THE PADDINGTON SOCIETY Inc.
For Community and Heritage
Est 1964

**RE: STATE SIGNIFICANT DEVELOPMENT SSD_10421
PROPOSED WEIGALL SPORTS COMPLEX SYDNEY GRAMMAR SCHOOL, NEILD AVE, PADDINGTON**

Drawing Title
**BUILDING 02
CAR PARK
GENERAL ARRANGEMENT PLAN
LOWER/UPPER GROUND**
Sheet Status
NOT FOR CONSTRUCTION

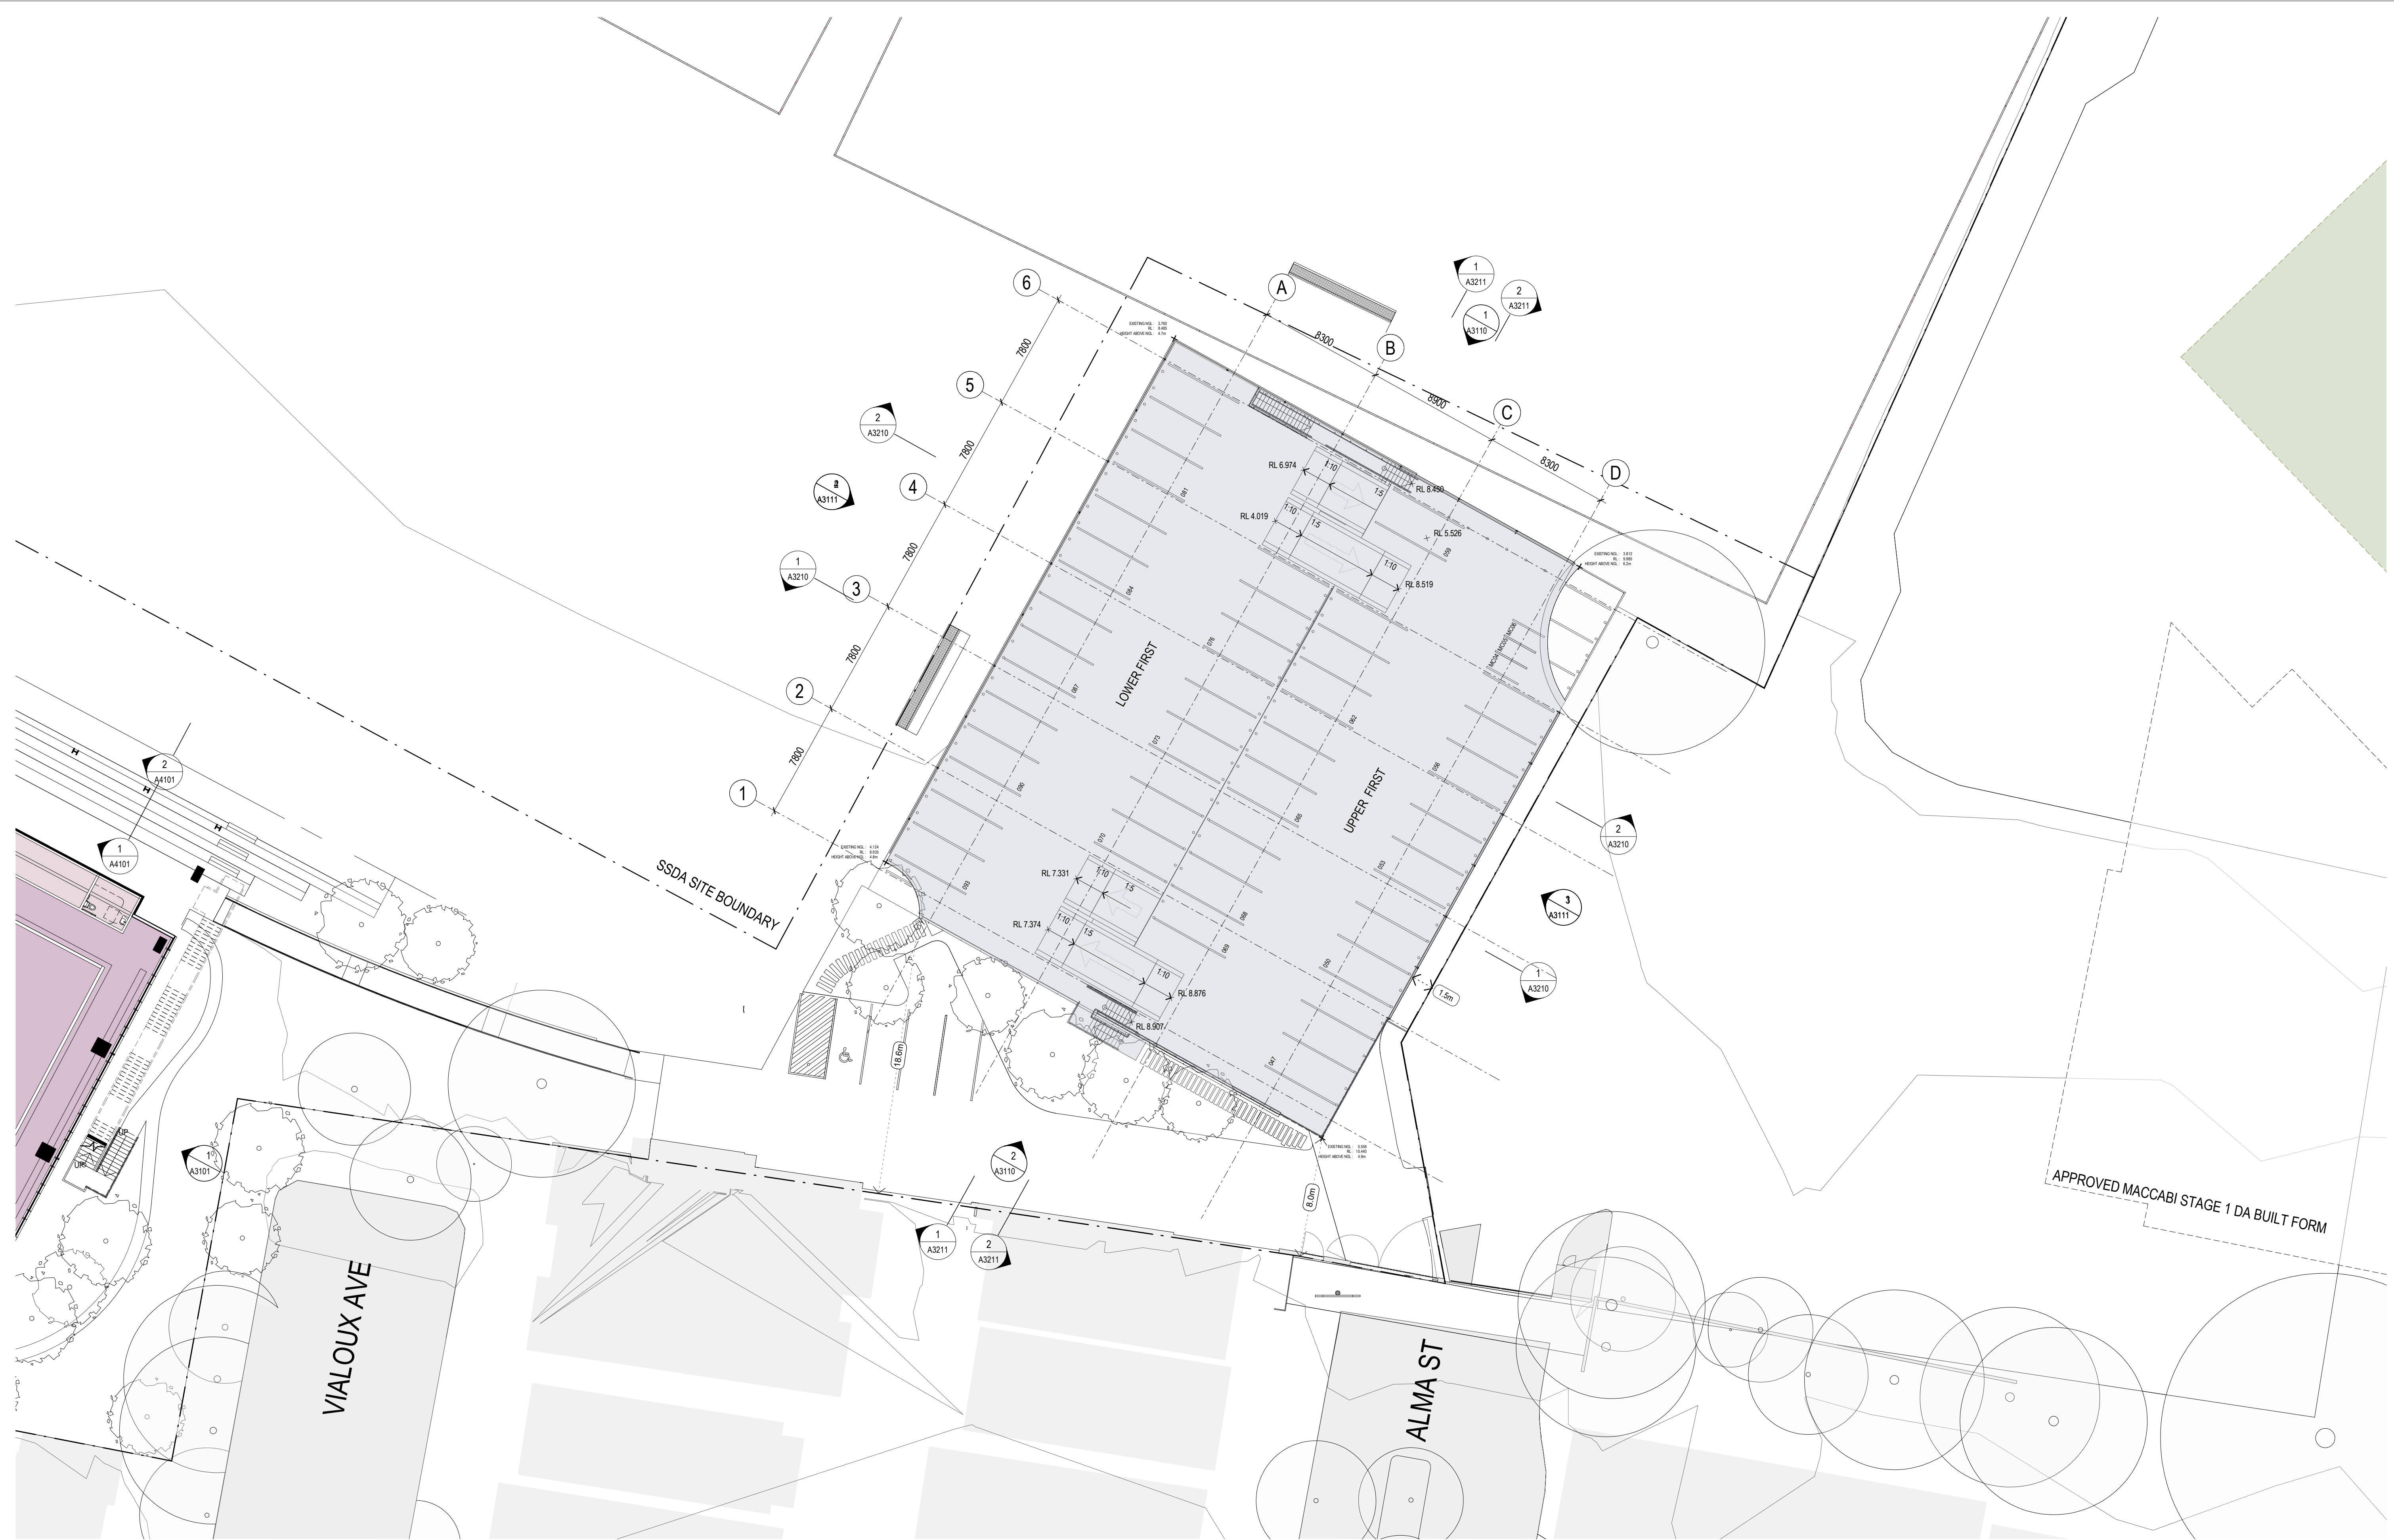
The proposal put forward is to erect a car parking structure of two levels on the valley floor, all accessed via a narrow two way pinch point from Alma Street. We are told that this car park, accommodating 97 cars in a split level form, will resolve the queuing issue by providing a vessel to accommodate cars waiting for students who are not yet ready to be picked up. The practicality of this concept is difficult to comprehend and we are certain that it will not resolve the problem of cars circulating and queuing along the narrow residential streets. There will be a natural tendency for parents to avoid entering a car parking structure and at best they would only tend to occupy ground levels holding some 50 cars.

The proposed car park, a two level structure in the open valley floor, is poorly sited and no amount of screening treatment to the facades will make it acceptable within the valley floor landscape.

1. The valley floor open space should be devoid of building structures and appropriately landscaped;
2. Building 2 is inappropriate and should be deleted;

Drawing Title
BUILDING 01
SPORTS FACILITIES BUILDING
ELEVATIONS
NORTH AND SOUTH

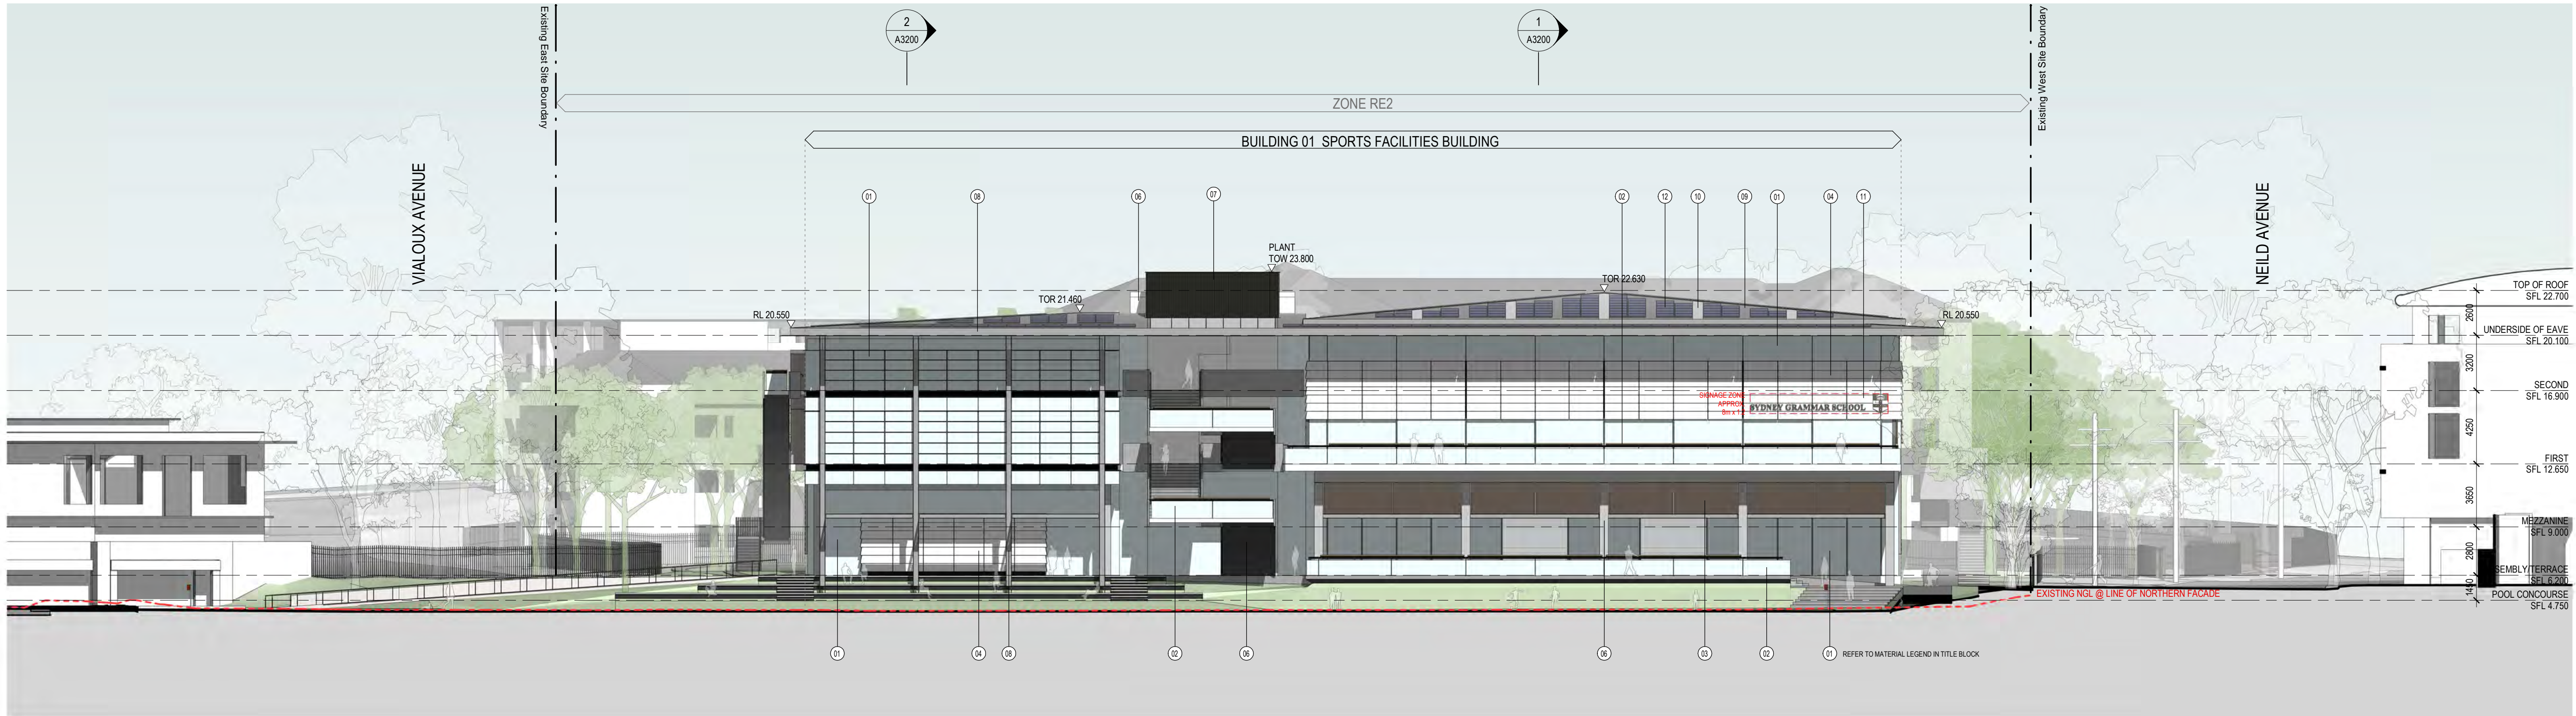
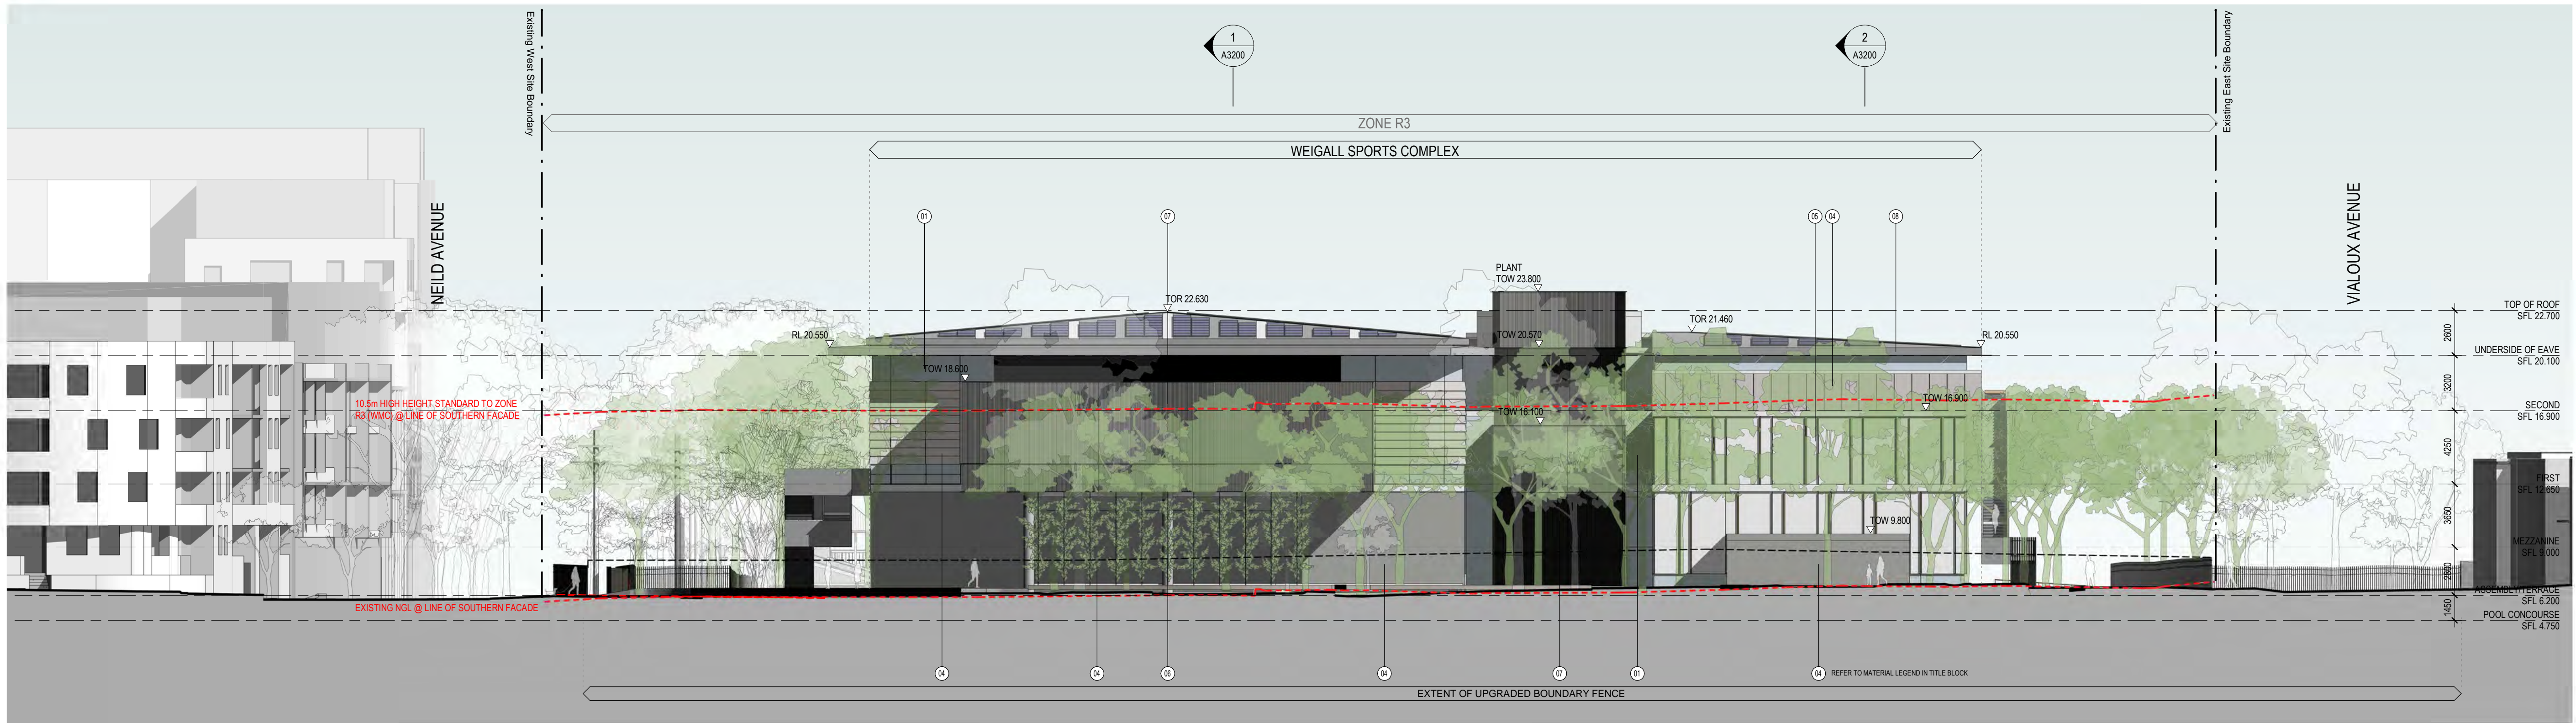
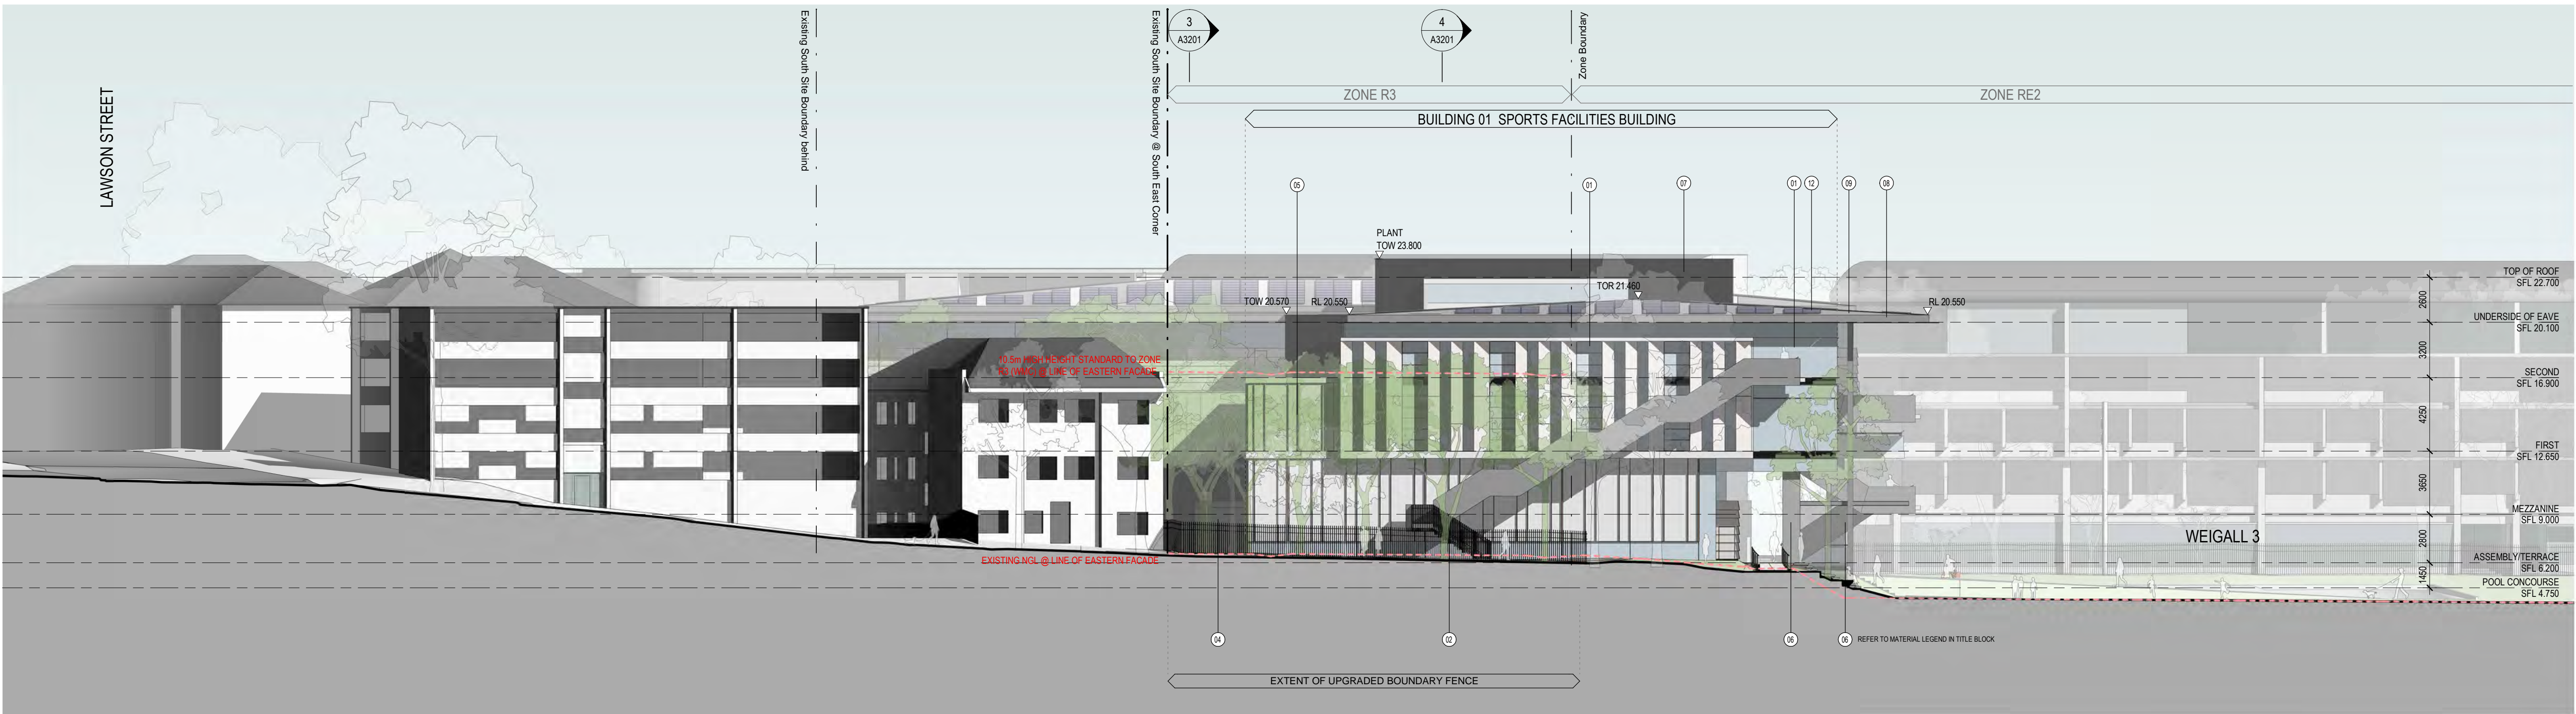
Building 1 at more than 17m (5 storeys) is much higher than the 10.5m maximum (3 storeys) in Woollahra Council's LEP for zone R3. The development application has been submitted under the provisions of Clause 42 of the Education SEPP and State Significant development which enables proposals with a Capital Investment Value of more than \$20 million to potentially set aside local controls:

In this instance, the height in excess of the Woollahra LEP, overshadows and is of excessive bulk and scale; it obstructs views of residents in 23-33 Lawson Street (65 apartments) and 8 Vialoux Avenue (12 apartments); the height should be reduced.

The drawings show plant rooms facing the southern boundary, but the application is silent on the location and nature of mechanical exhausts, especially from pool facilities where chlorine or other such noxious substances may be present.
